RESERVED MATTERS APPLICATION 2025/92713
REAR OF 23 TO 43 MOOR LANE, GOMERSAL, BD19 4LF
SUMMARY OF CHANGES, JUNE 2026

Client PPJ Developments  
 Project 2539 : Moor Lane : Residential  
 Title Proposed Site and Section

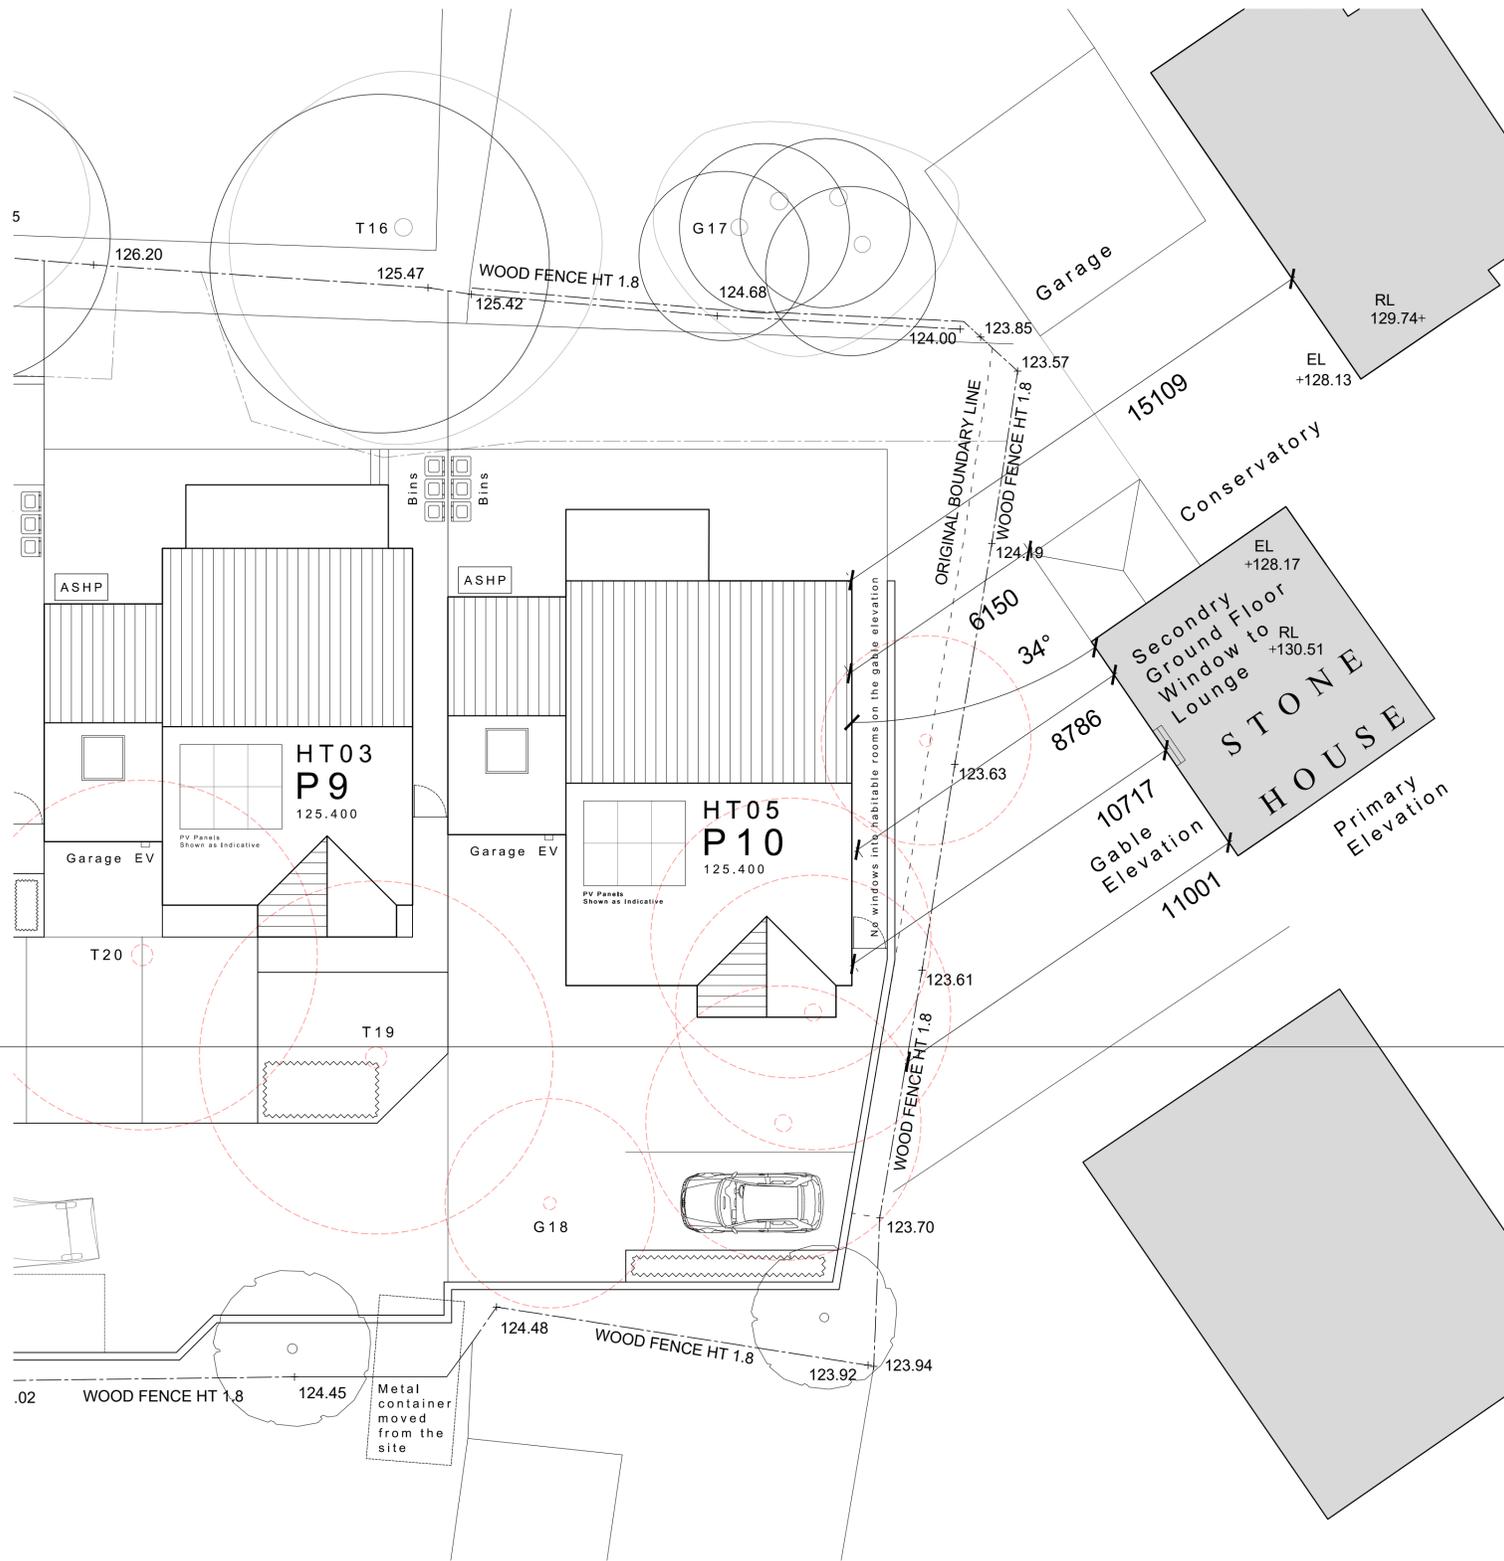
- 5) The separation distance between the house on Plot 10 and No. 21 Summerdale has been increased substantially from 8 metres to 15.3 metres by fully relocating the house.

- 6) The ridge height of the dwelling has been reduced by almost one metre, to further lessen any impact on No. 21 Summerdale.
- 7) The size of the retaining wall on Plot 10 has been reduced from 1.65 meters to just over half a metre in height.

HOUSE TYPE 02A

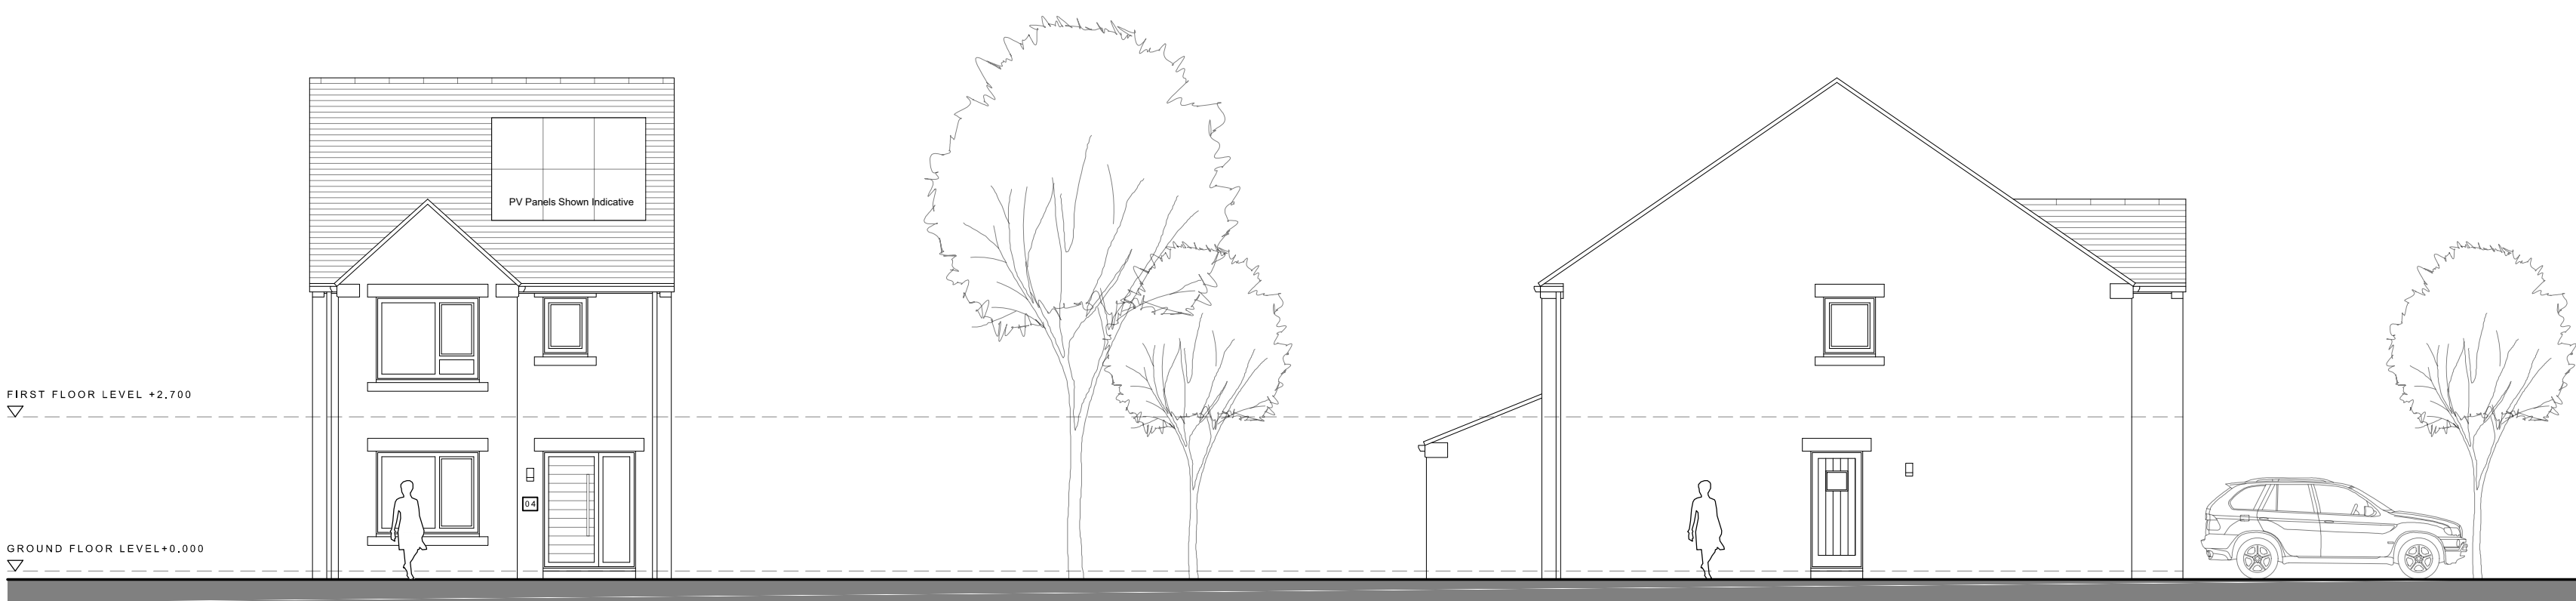
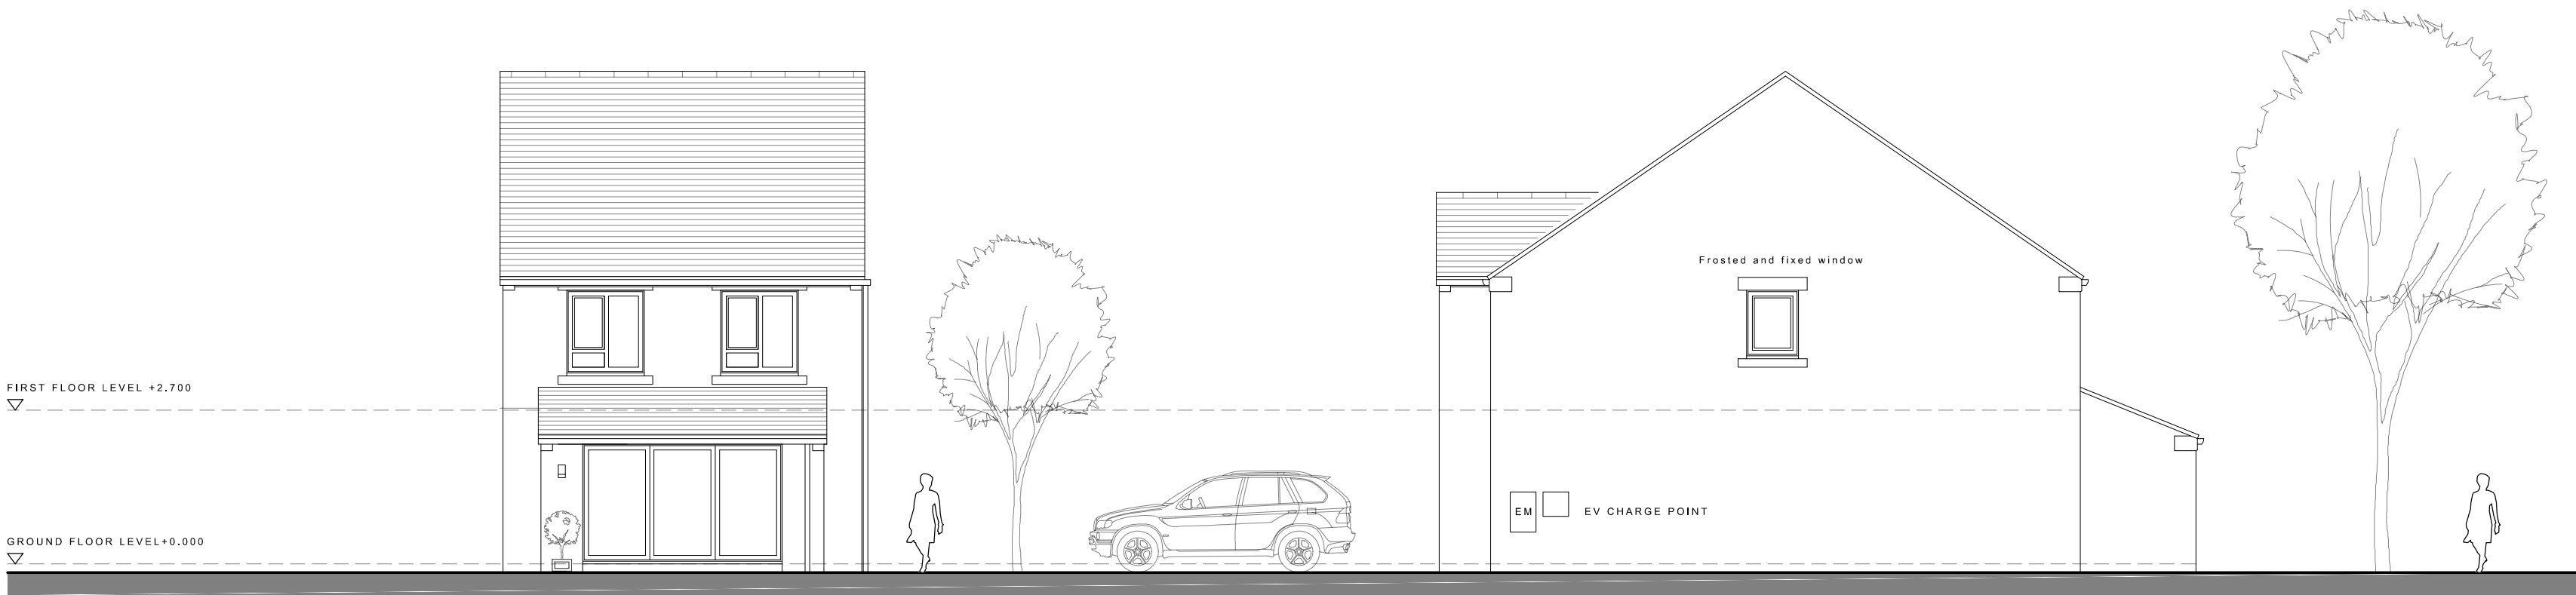
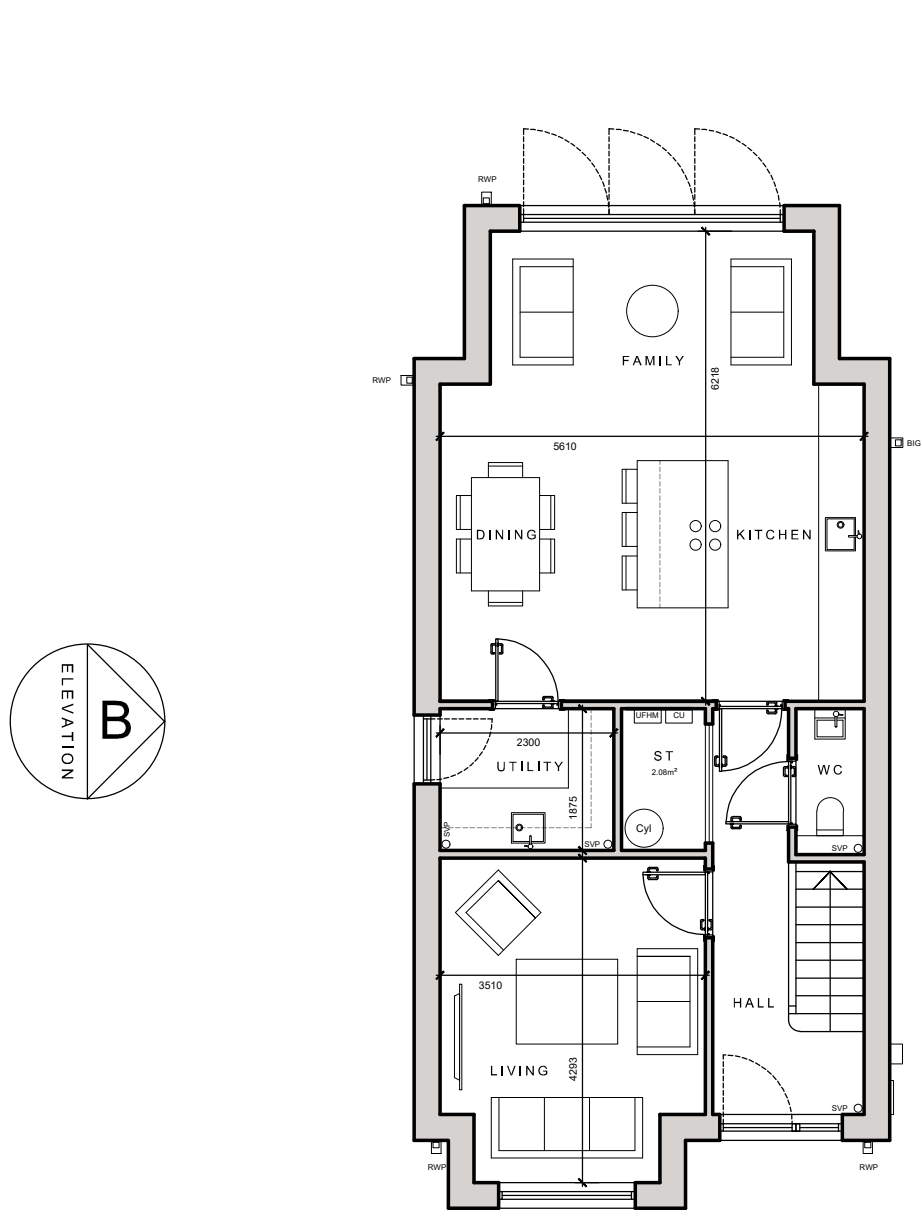
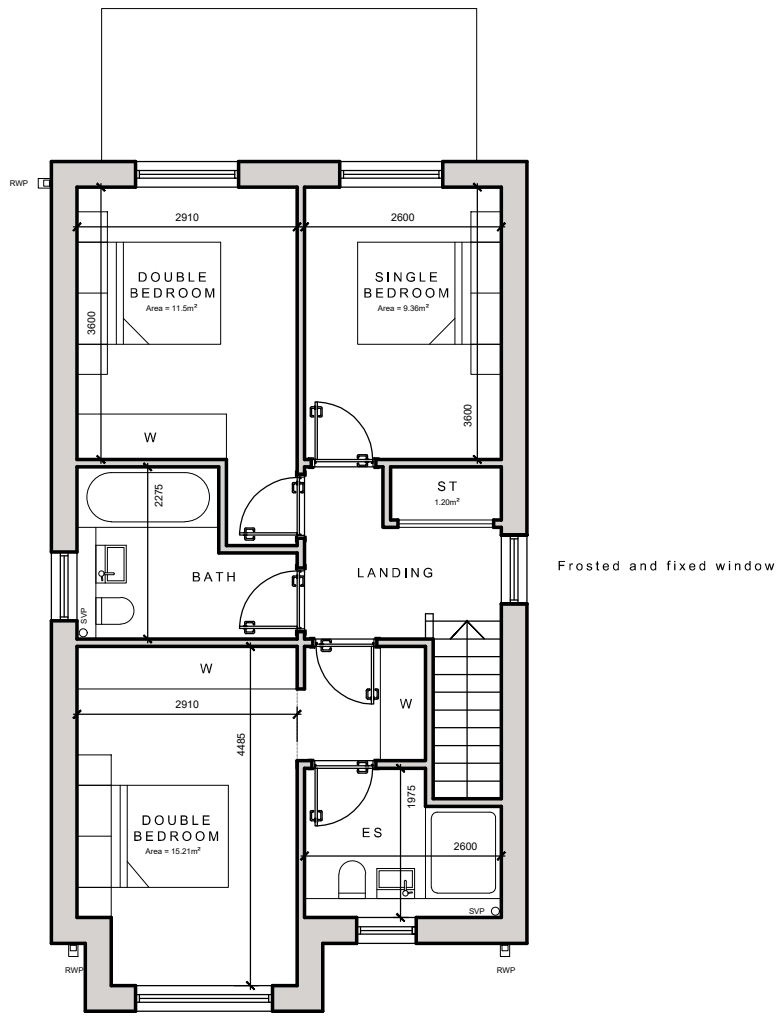
- 1) The house on Plot 10 has been reduced from a five-bedroom dwelling to a three-bedroom property.
- 2) The garage associated with Plot 10 has been removed.

- 3) The house on Plot 10 has been significantly reduced by 35% in size from approximately 2,000 square feet to 1,300 square feet.
- 4) The footprint has also been made considerably narrower to maximise the separation distance between properties.
